Ribble Valley Borough Council
Council Offices
Church Walk,
Clitheroe
Lancashire
BB7 2RA

Phone: 0300 123 6780
Email: developeras@lancashire.gov.uk
Your ref: 3/2025/0861
Our ref: 3/2025/0861/HDC/KW
Date: 23 January 2026

Location: Burnhouse Farm Back Lane Slaidburn BB7 3EE
Proposal: Proposed construction of No.3 camping lodges and a utility hut including associated hardstanding and landscaping.
Grid Ref: 368160 452765

# Laundry & Bike Shed

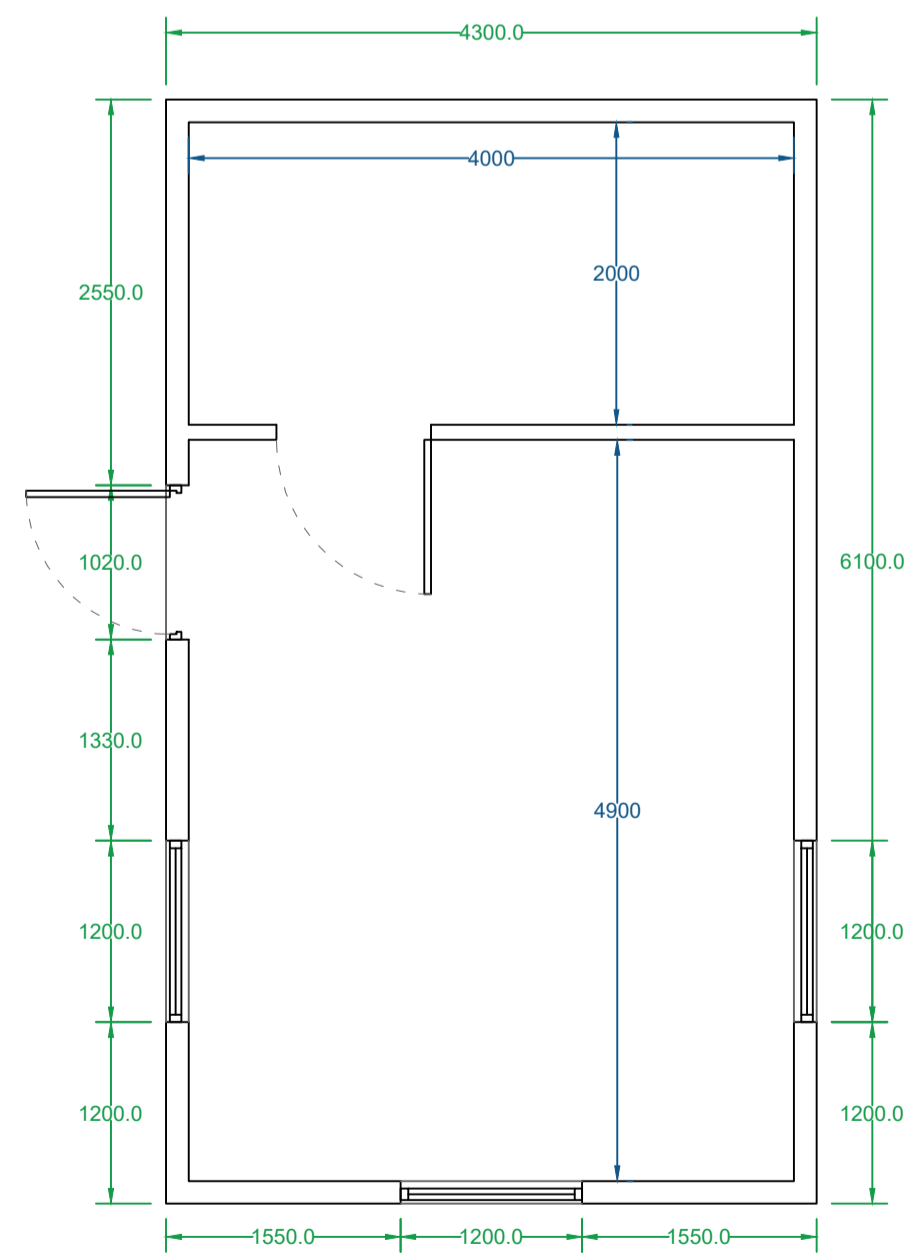
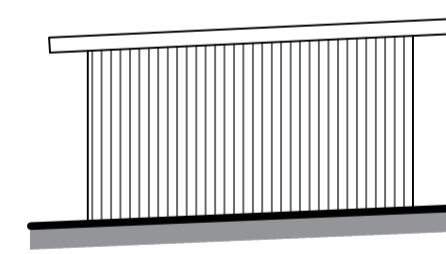
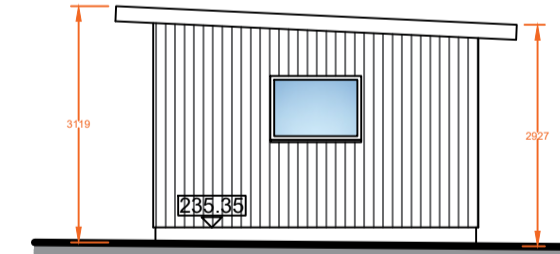
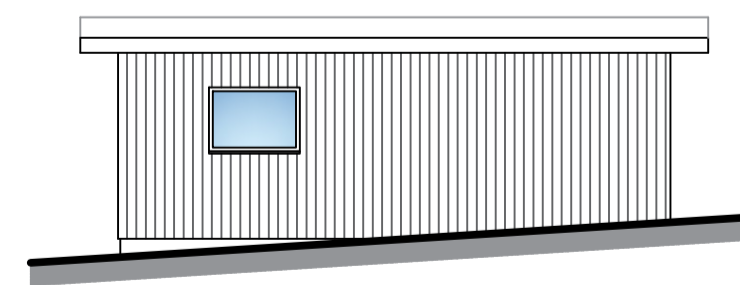
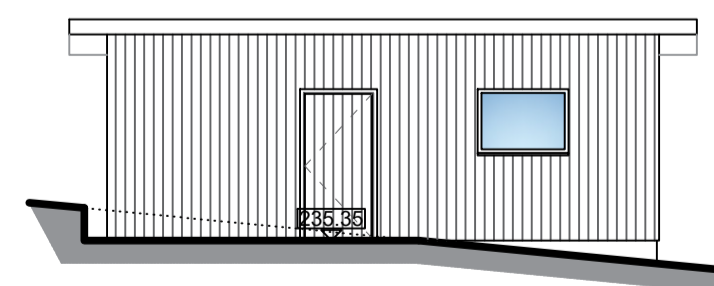
The site shall enhance its sustainable transport options to actively encourage and support sustainable transport use. The LHA notes that the development includes covered and secure cycle storage, as seen on drawing C193-5 – 008 Rev E, which will ensure adequate parking provisions and promote cycling as a sustainable mode of transport.

**Proposed Site Plan**  
 Scale (1:500)

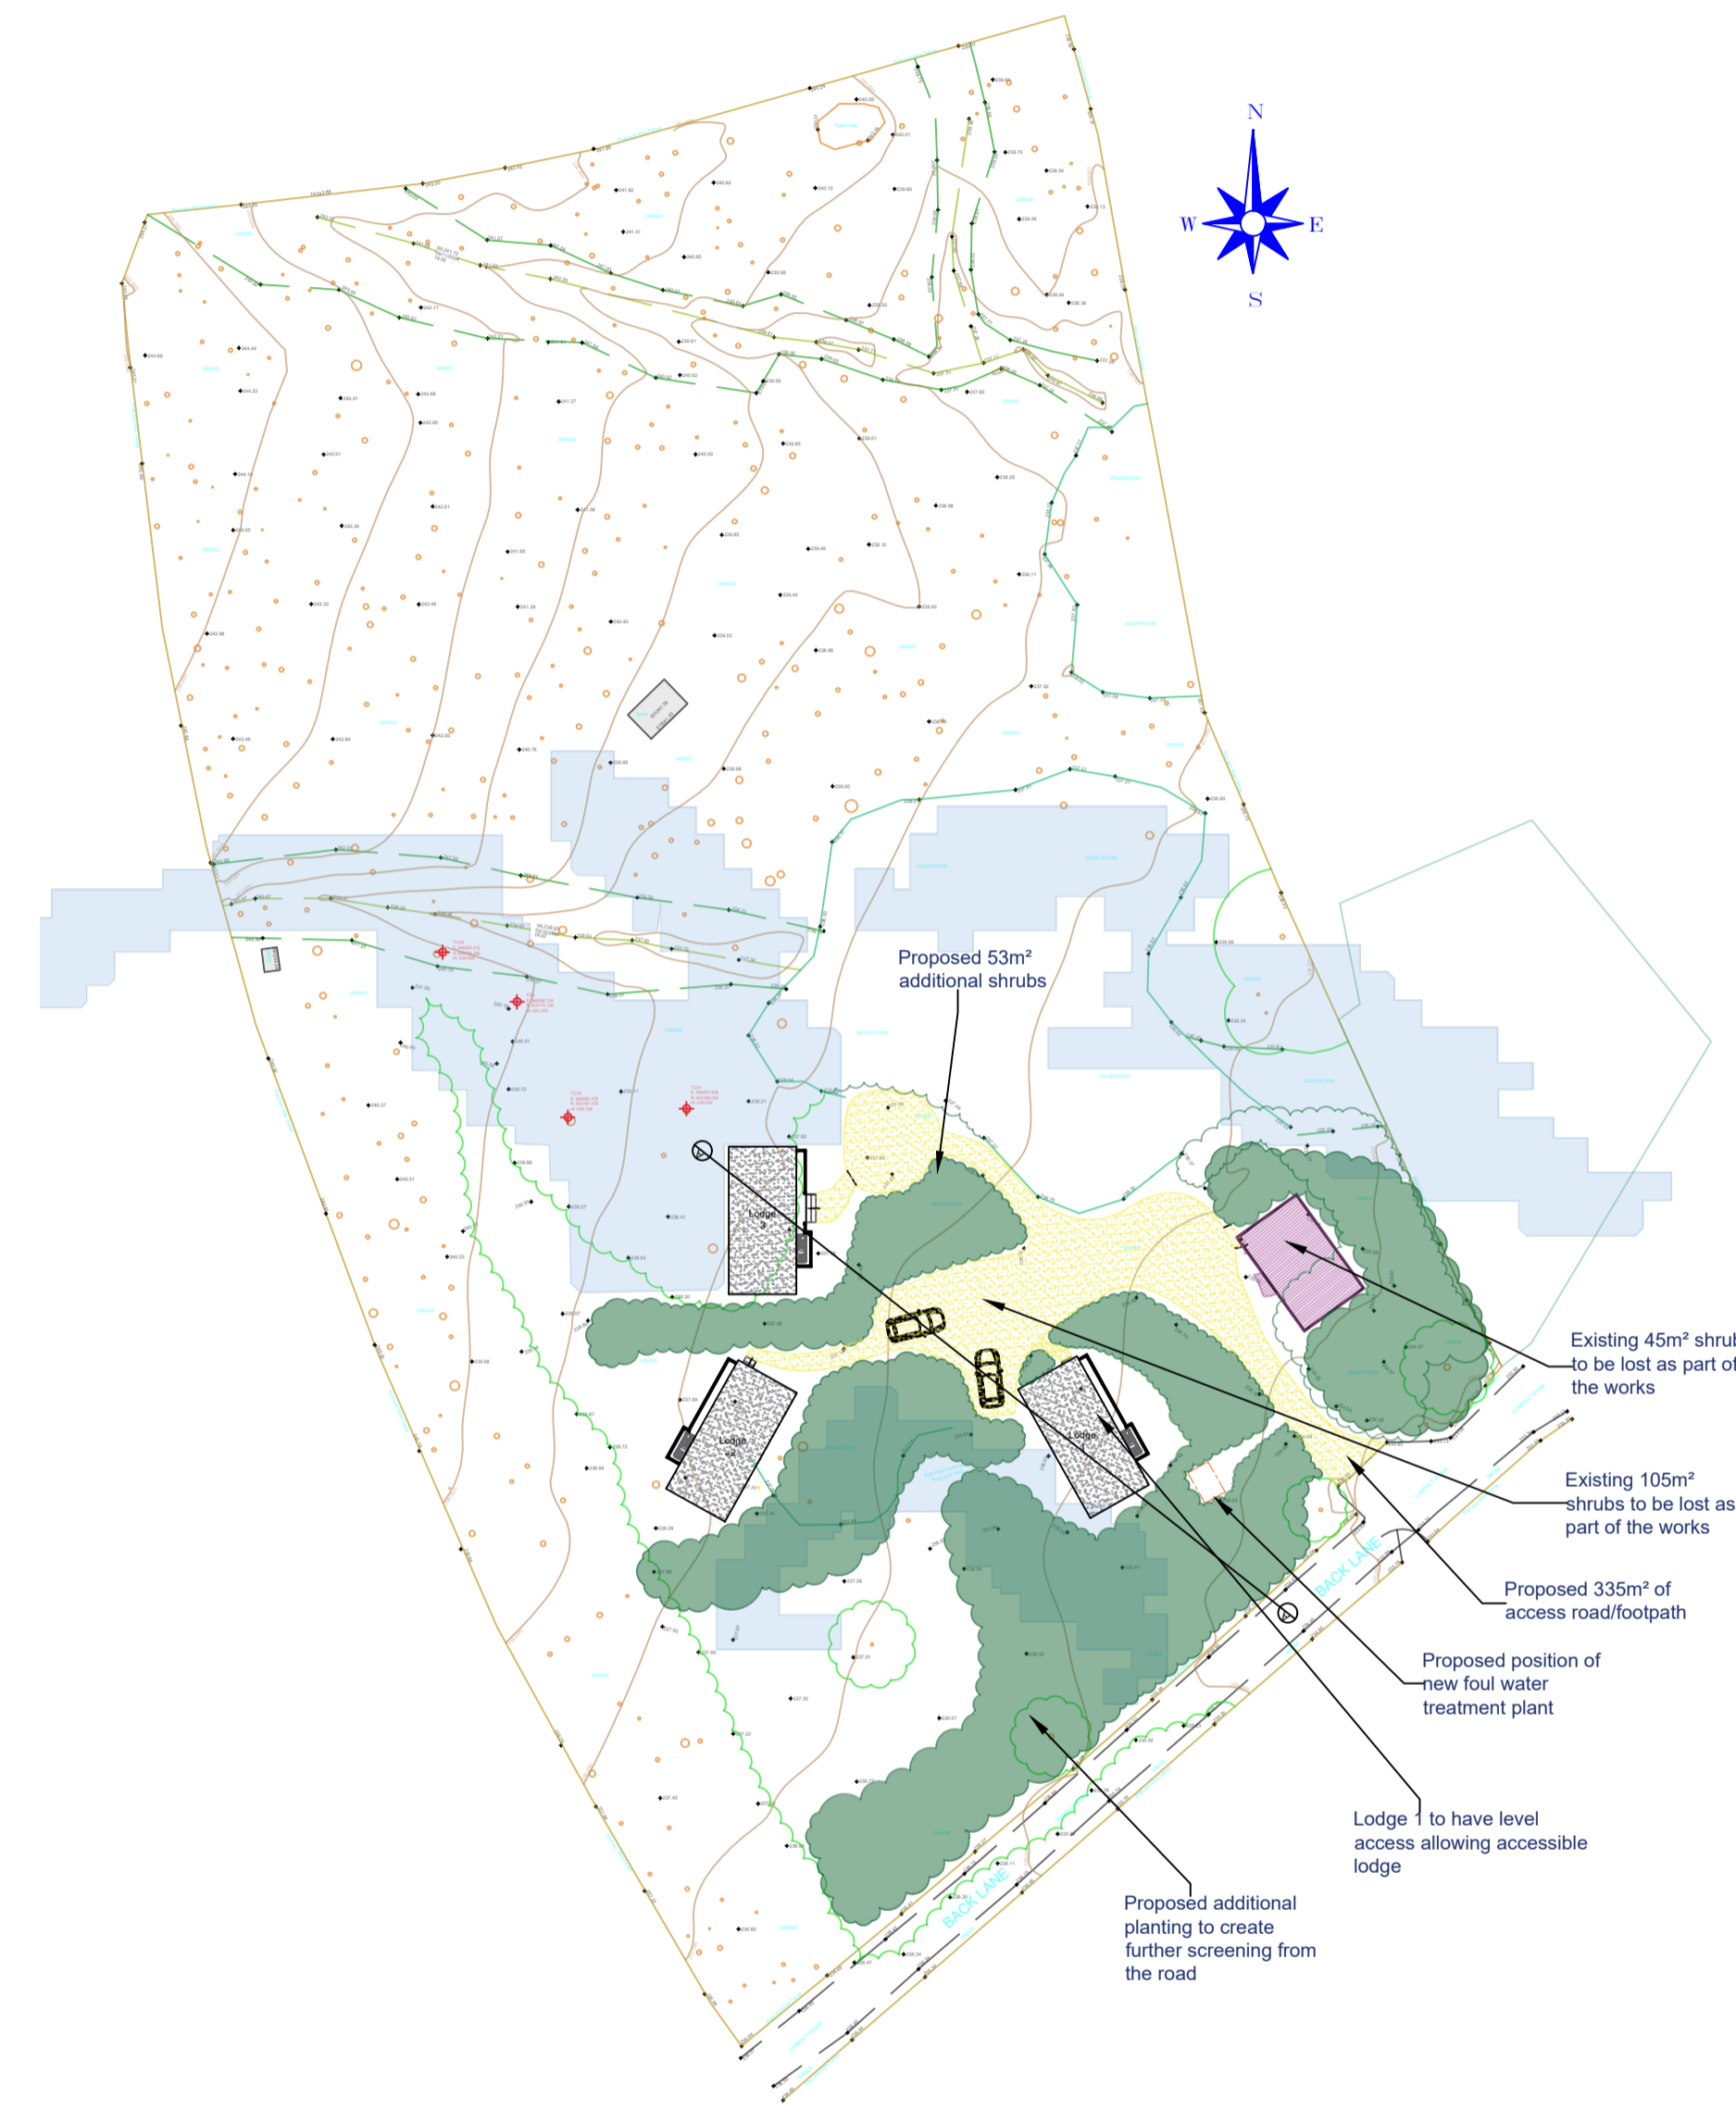
The LHA have reviewed the Proposed Site Plan, drawing C193-5 – 007 Revision F and are aware that the holiday pods are provided with one parking space each. The pods each provide one bedroom and as such the parking provisions are acceptable to the LHA. There is also room to turn within the site, allowing for ingress and egress in a forward gear.

3. No part of the development hereby permitted shall be occupied until such time as the access arrangements shown on drawing number C193-5 – 007 Revision F have been implemented in full.
